# BCA 2022 AMENDMENT 2 CAPABILITY REPORT FOR SSDA SUBMISSION

<b>CLIENT:</b>	TQM
<b>PROJECT NAME:</b>	LOTUS, HURSTVILLE MIXED USE DEVELOPMENT
<b>PROJECT ADDRESS:</b>	105 FOREST ROAD & 1A HILL ST, HURSTVILLE NSW 2220
<b>DATE:</b>	10 SEPTEMBER 2025
<b>PROJECT NO:</b>	250343

CLIENT: TQMDC
LOTUS, HURSTVILLE
ADDRESS: 105 FOREST RD & 1A HILL ST, HURSTVILLE
DRAWING NAME: LEVEL 2 FLOOR PLAN

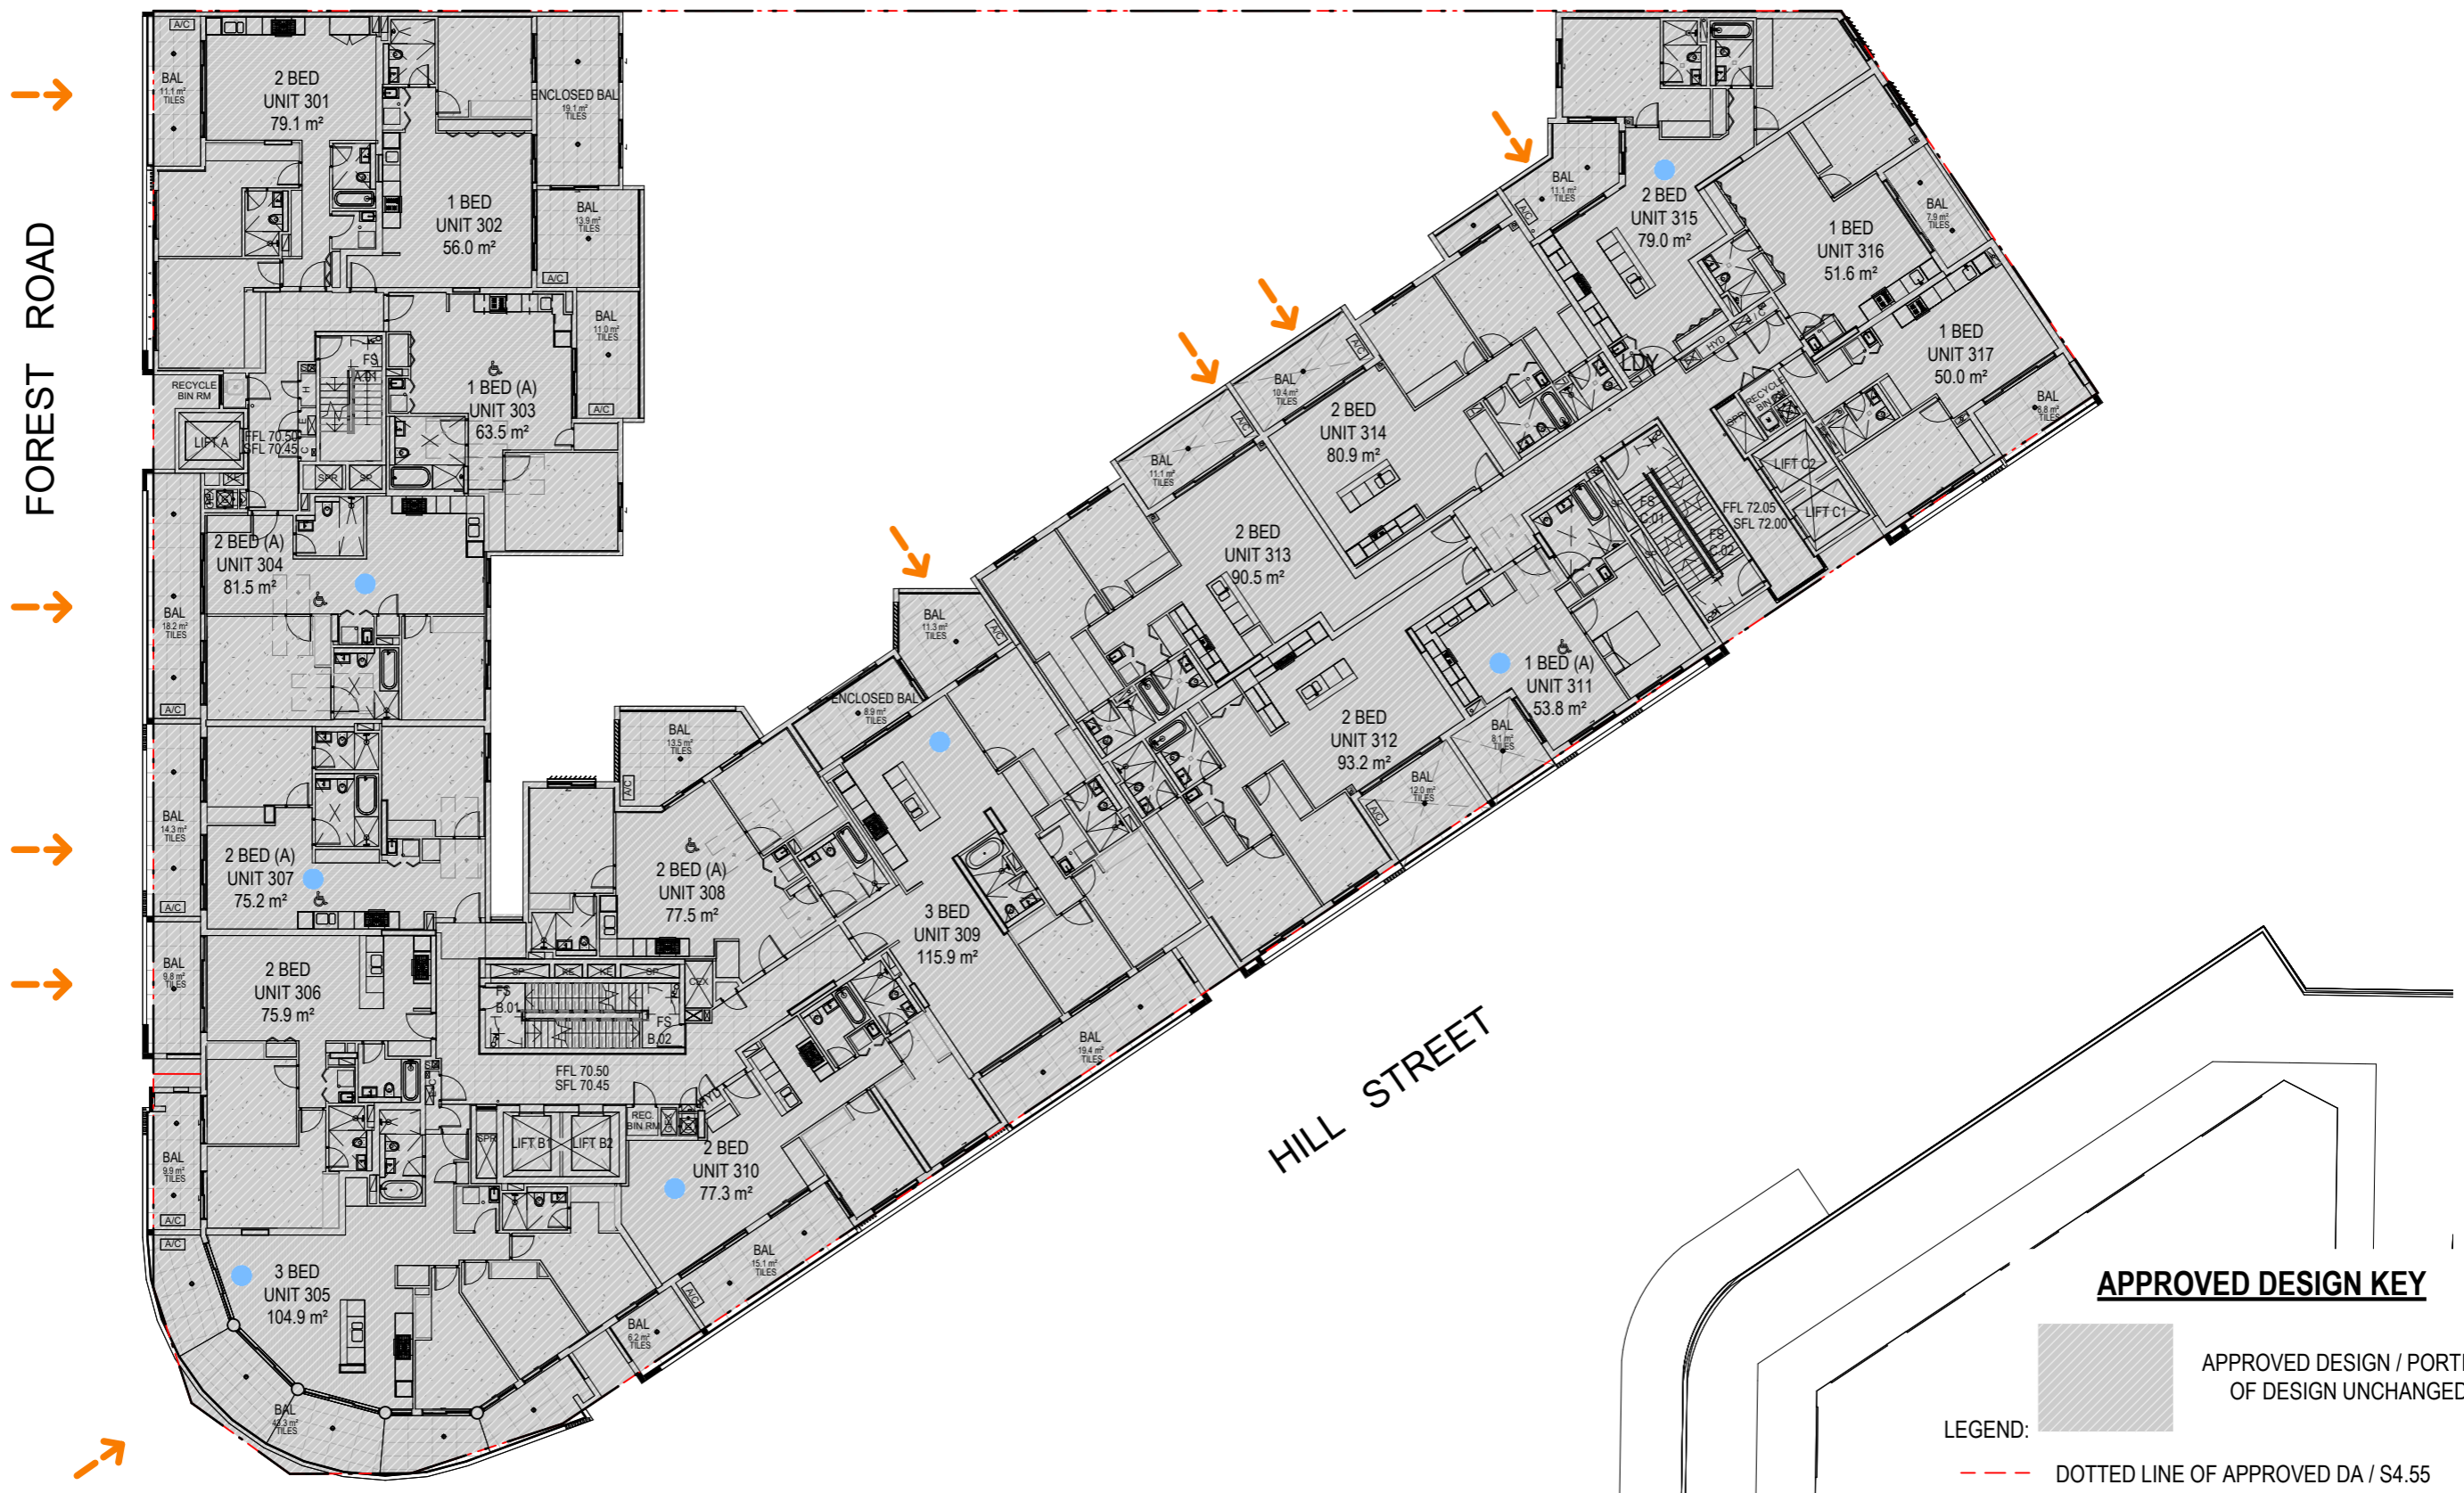
Levels 2 – 7:

Only 1 exit is provided. Refer to the figure below showing the single exit design on Level 2.
